From: Chantelle Bashford [REDACTED]
Sent: 09 April 2026 17:00
To: Planning.Responses <Planning.Responses@arun.gov.uk>
Subject: RE: Planning Consultation on: BR/20/26/PL

Application No: BR/20/26/PL

Site Address: 51a Aldwick Road Bognor Regis PO21 2NJ

Description of Works: Retention of change of use of first and second floor office to an 5 bed HMO.
This application is in CIL Zone 4 (Zero Rated) as other development.

PROPOSED FIRST FLOOR PLAN

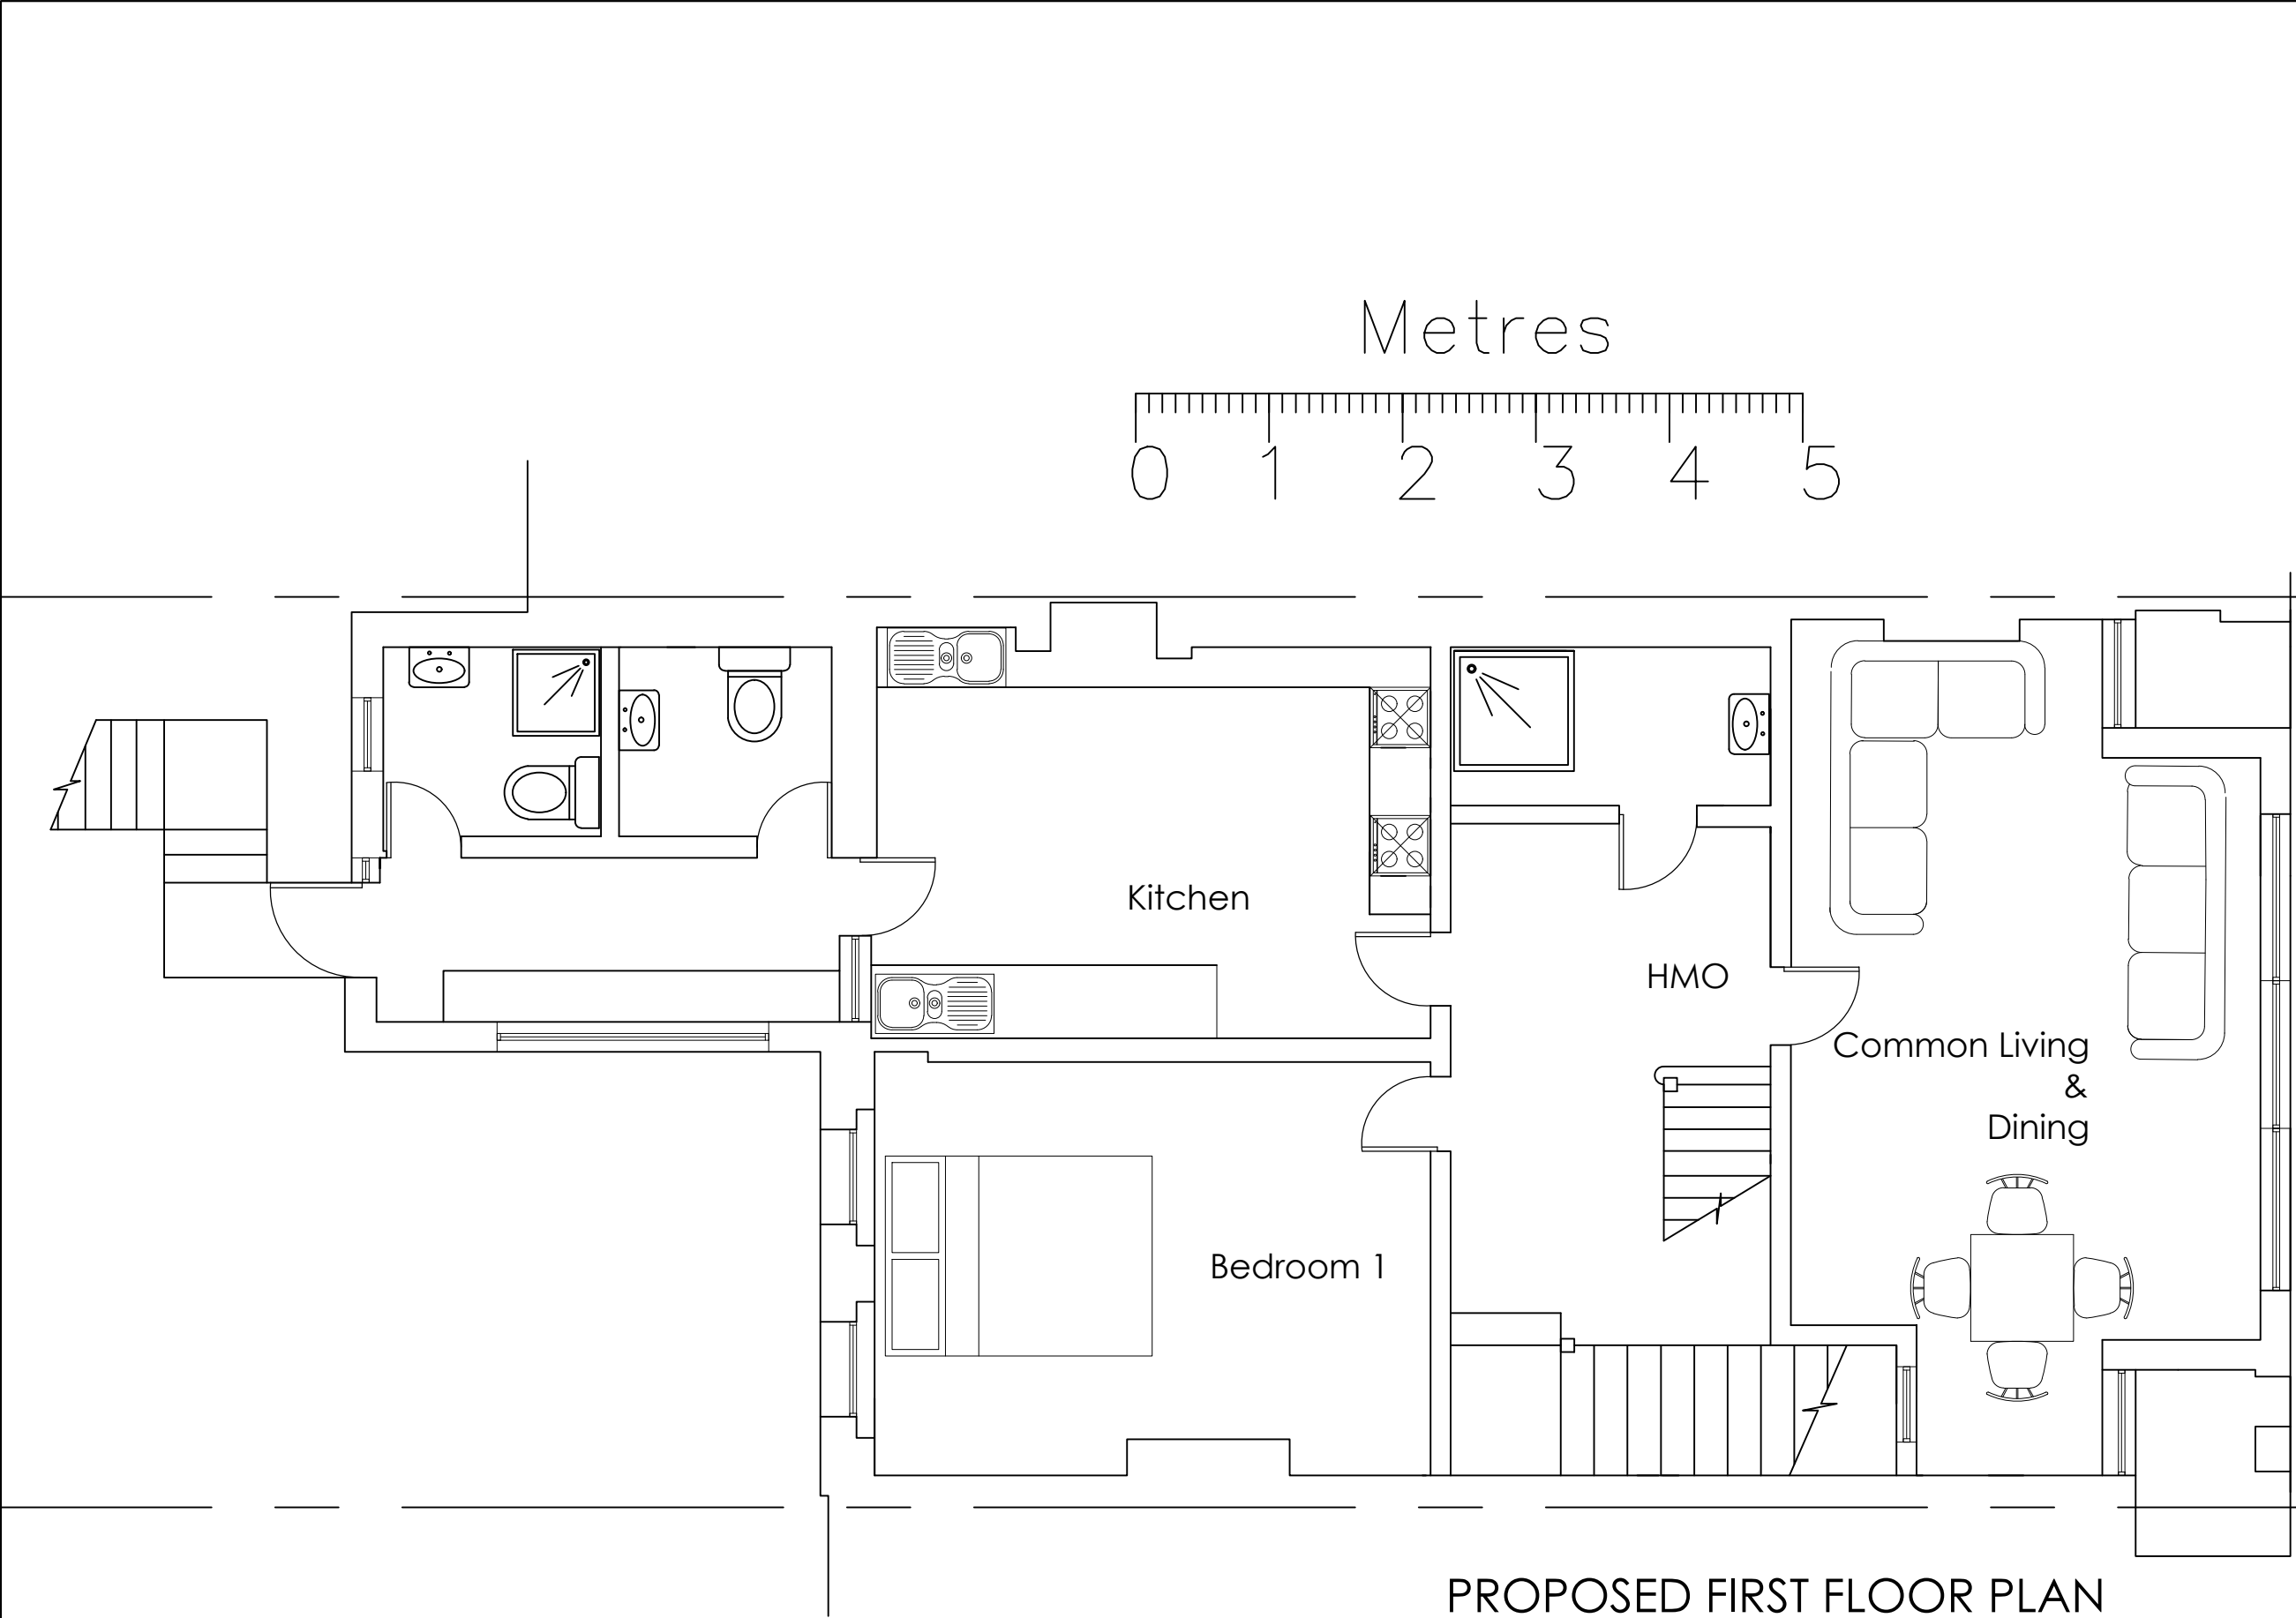
Based on five occupants the kitchen is required to be min. 7m² with the living/dining room measuring min. 13m². However, the proposed plan suggests that the intention may be to have two occupants within some of the bedrooms, therefore an additional 1.5m² is required for each additional occupant above five for the kitchen, and 1.5m² for each additional occupant above six for the living/dining room. For example, nine occupants would increase the kitchen to 13m² and the living/dining room to 17.5m².

- The proposed layout of the kitchen appears to show insufficient worktop space for five occupants. A minimum of 500mm (L) x 600mm (D) is required per person (smaller lengths of less than 500mm cannot be counted towards the overall requirement). Looking at the proposed plans the worktop located on the far side of the kitchen appears narrow with the depth unlikely to achieve 600mm. Consideration should therefore be given to reconfiguring the kitchen to ensure sufficient worktop space can be provided – please refer to Arun's HMO standards.
